OXFORDSHIRE COUNTY COUNCIL'S RESPONSE TO CONSULTATION ON THE FOLLOWING DEVELOPMENT PROPOSAL

Application no 14/02004/HYBRID:

Location: Land South Of Perdiswell Farm Shipton Road Shipton On Cherwell

ANNEX 1
OFFICER ADVICE

JOB TITLE		Woodstock East		CLIENT		Pye Homes Vanbrugh Trust	
DRAWING TITLE							
Proposed Transport Connections							
SCALE	DRAWN BY	DATE	DRAWING No	REVISION			
1:2500@A1	BP	Oct14	15291-19	E

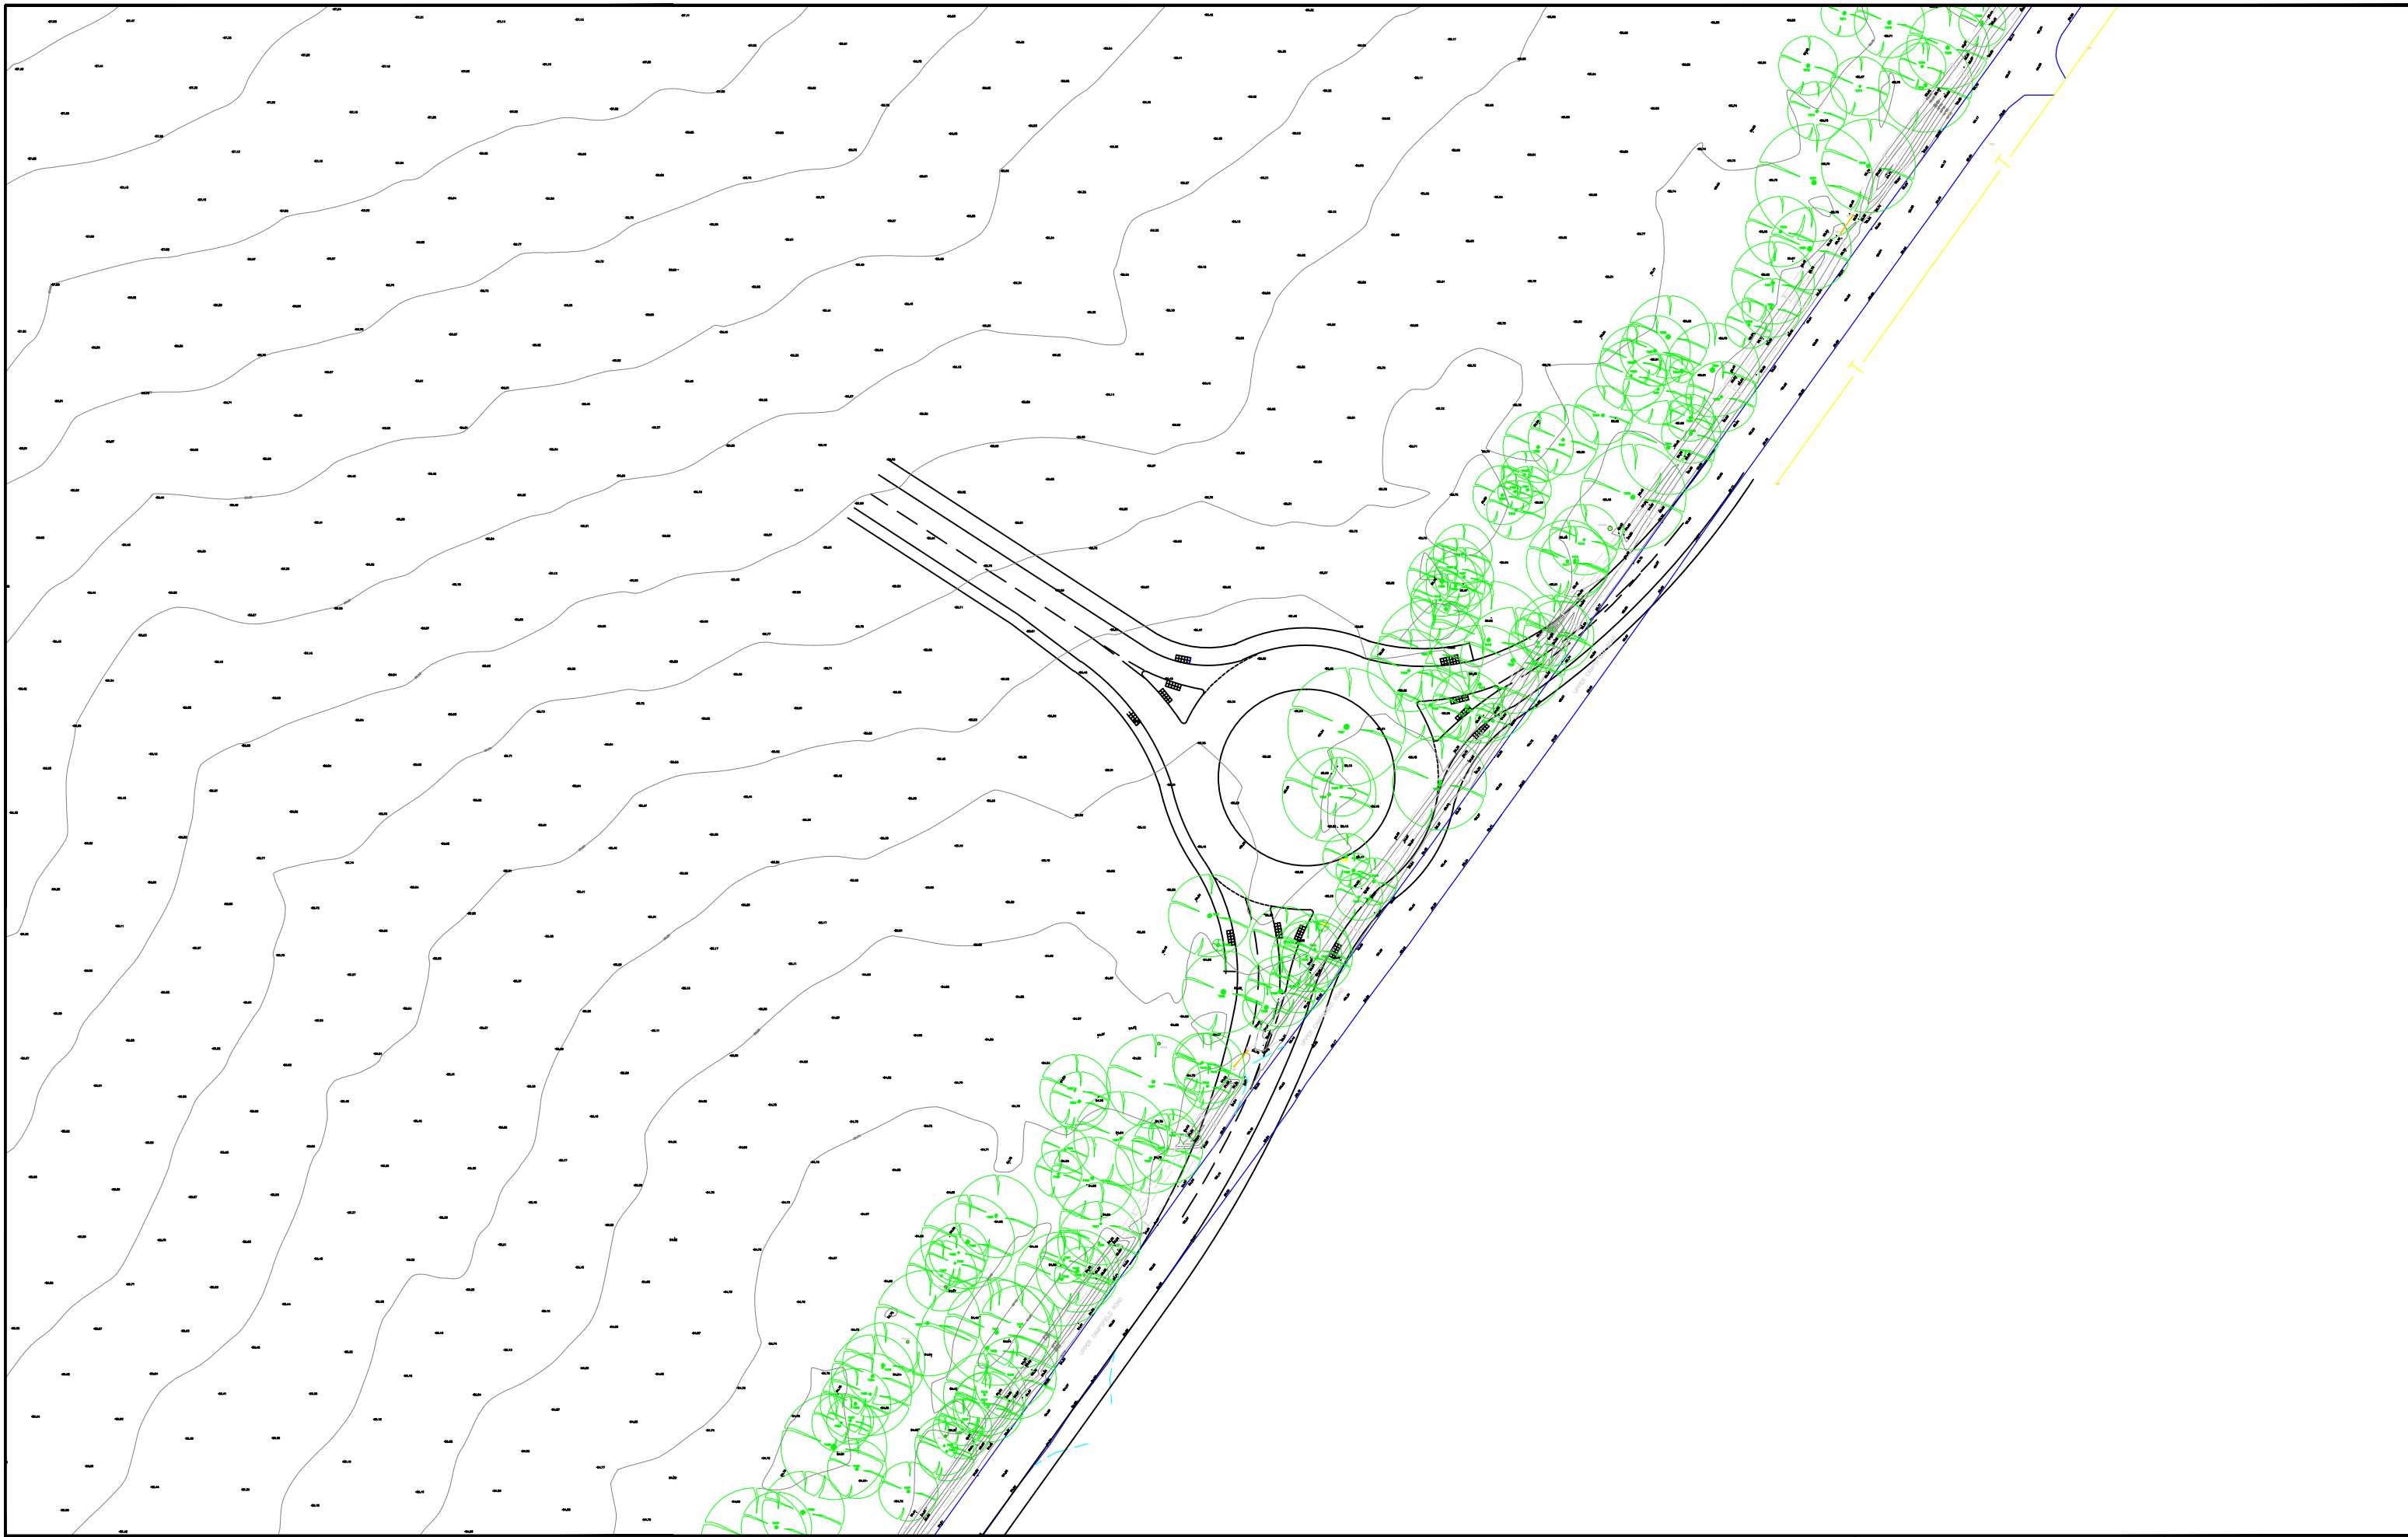
I note, due to the green Bat Corridor, there is only one road route joining the eastern and western parts of the site. This means that there is only one road route between the primary school and local centre in the eastern part of the site and the main residential area in the west. It is noted in, addition to the single road, there is two pedestrian/cycle paths crossing the Bat Corridor, it is essential high quality, direct and convenient routes join the two parts of the site to ensure people travel sustainably for local trips. The internal walking & cycling routes need to join up directly with the identified paths leading to the existing urban area.

The master plan provided with the application shows some of the proposed walking and cycling links off the site, more details is need on how these will link in with the existing town links.

JOB TITLE		Woodstock East		CLIENT		Pye Homes & Vanbrugh Trust	
DRAWING TITLE							
Proposed 45m Roundabout Access							
SCALE	DRAWN BY	DATE	DRAWING No	REVISION			
1:1000@A3	BP	Sept14	15291-21	A

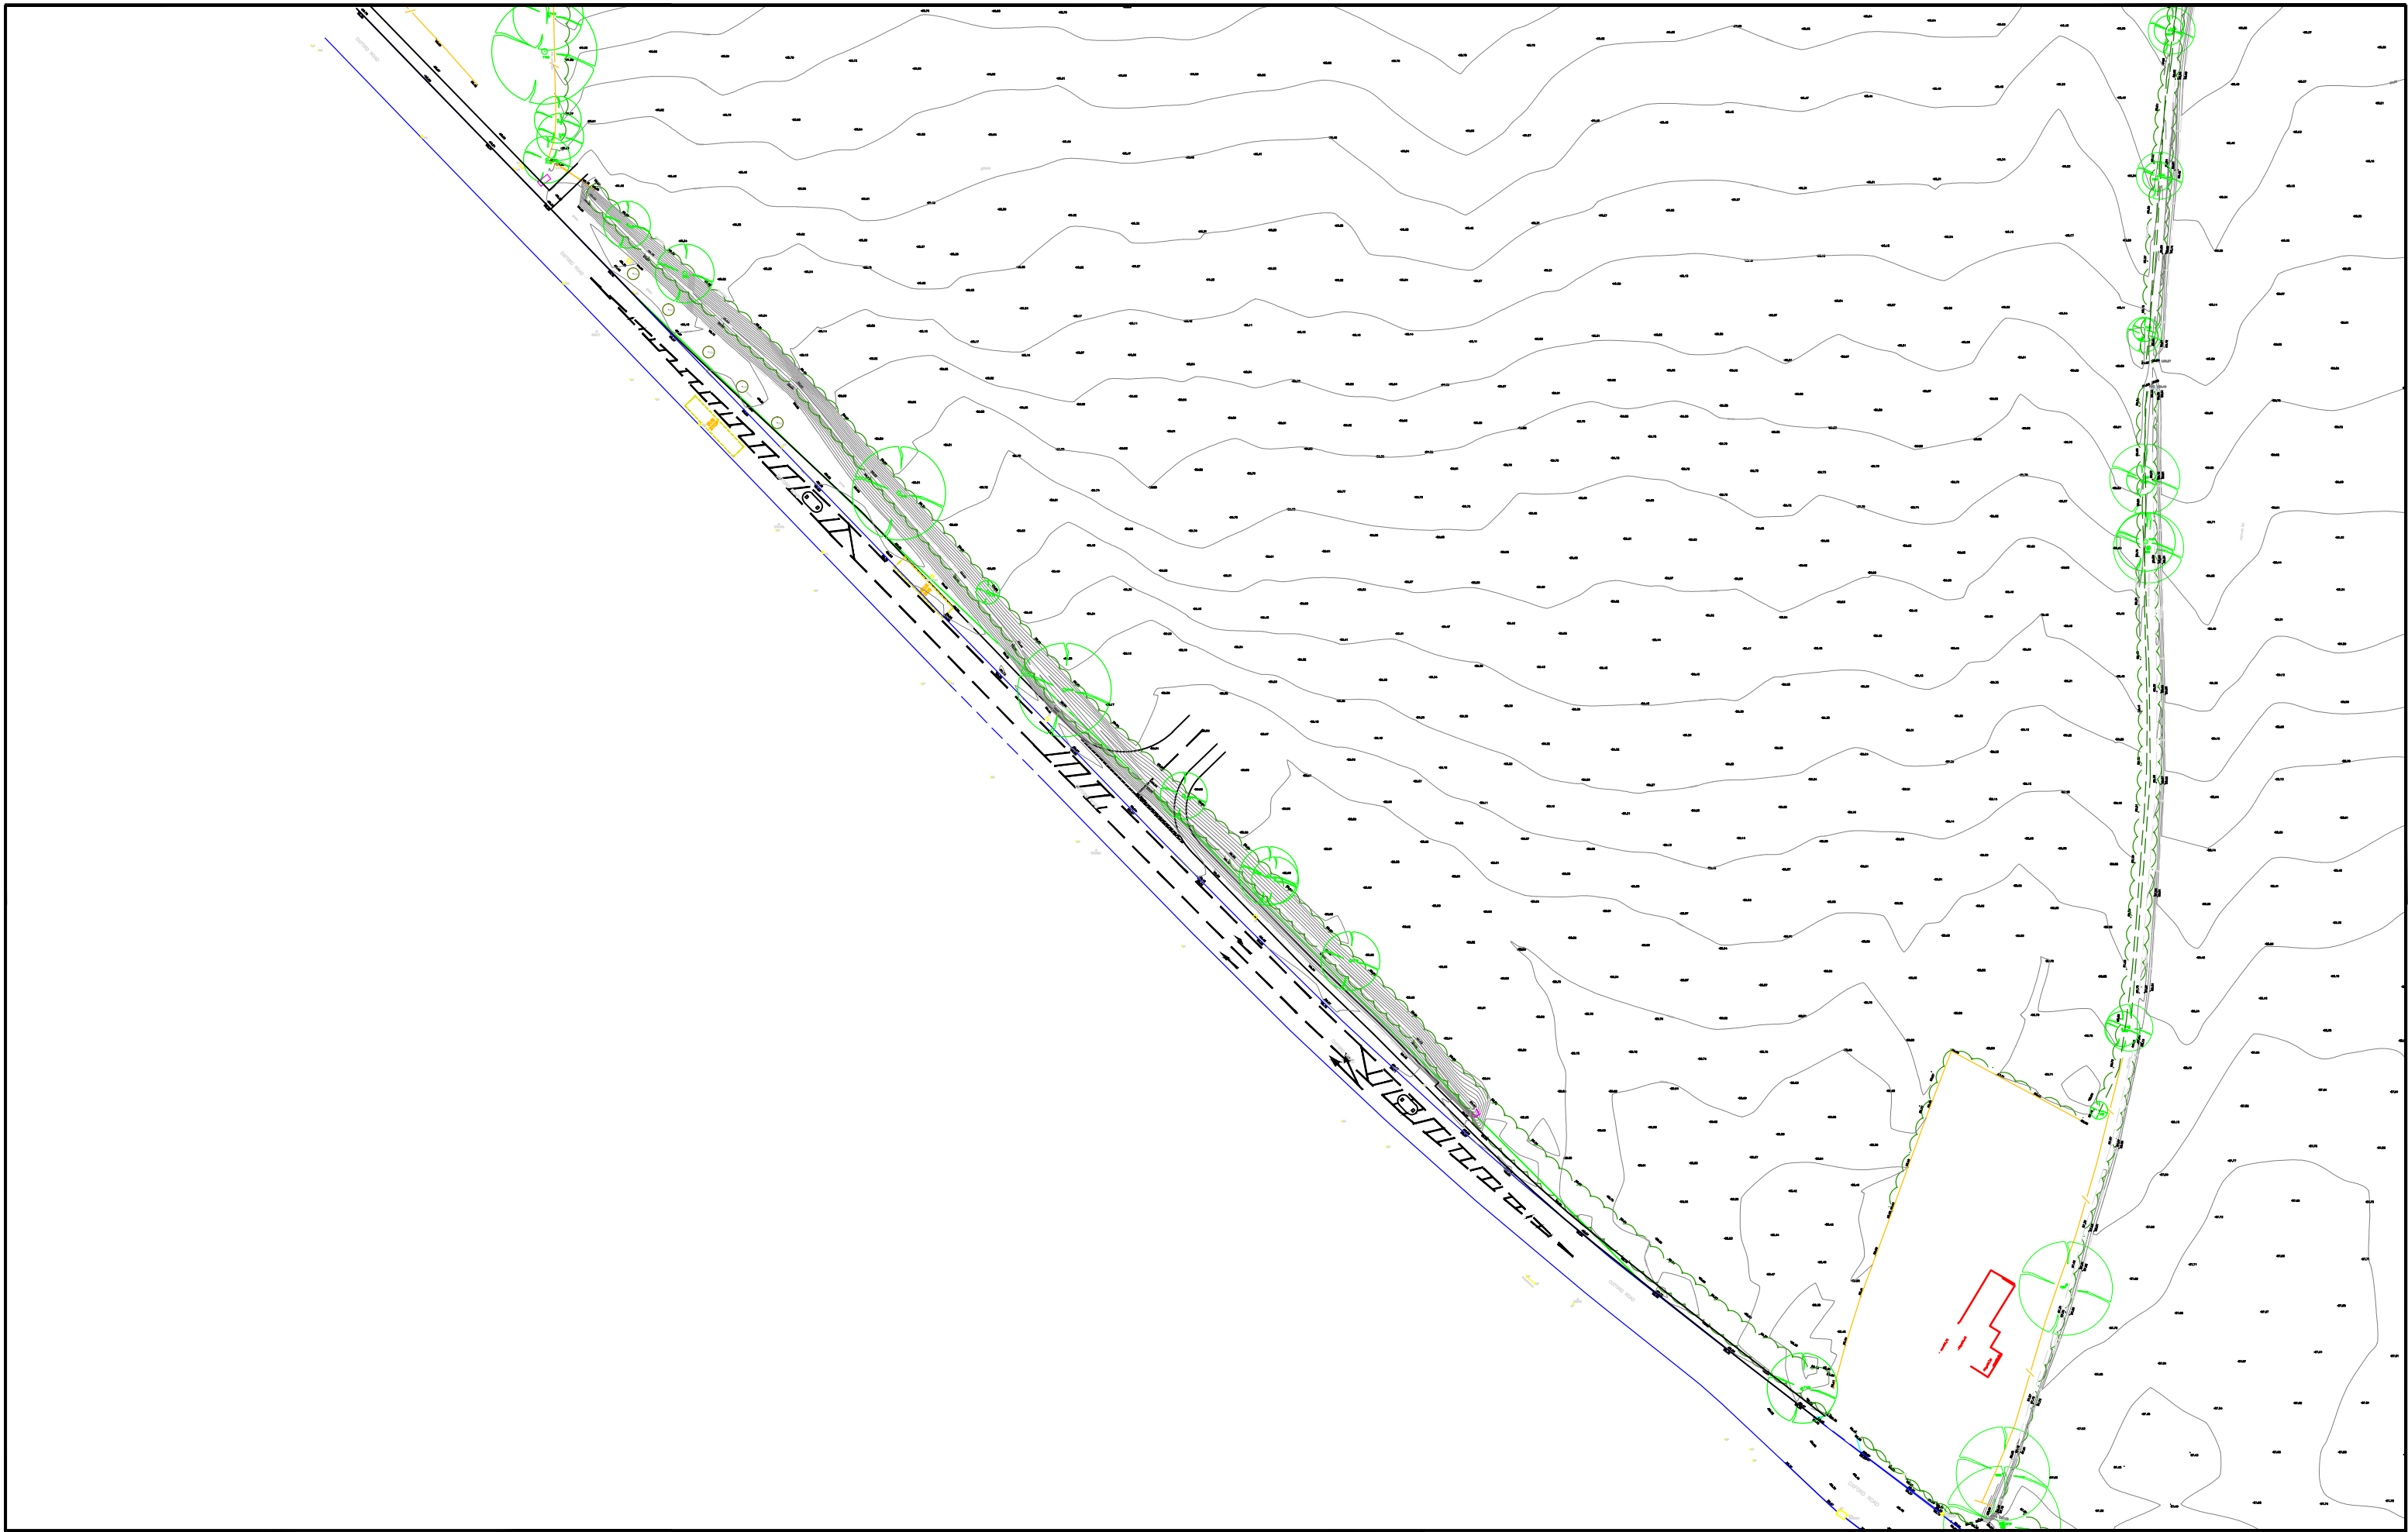
- i) the proposed priority junction to the A44 is in close proximity to an existing junction on the opposite of the road.
- ii) the layout of the proposed roundabout to A4095

- iii) the proposed priority junction to the A44 is in close proximity to an existing junction on the opposite of the road.
- iv) the layout of the proposed roundabout to A4095

Further detail is required of the site access proposal. I have concerns with regard to highway safety and convenience as the submitted plans do not appear to be in accordance with Design Manual for Roads and Bridges (DMRB). For the access to the A44 my attention is drawn to the access opposite and the lack of junction separation. For the roundabout proposed at the A4095 junction I am concerned with the poor alignment and dimension of the roundabout. The proposals should be revised to accord with DMRB and I suggest appropriate Road Safety Audits are provided with any departure from DMRB appropriately justified.
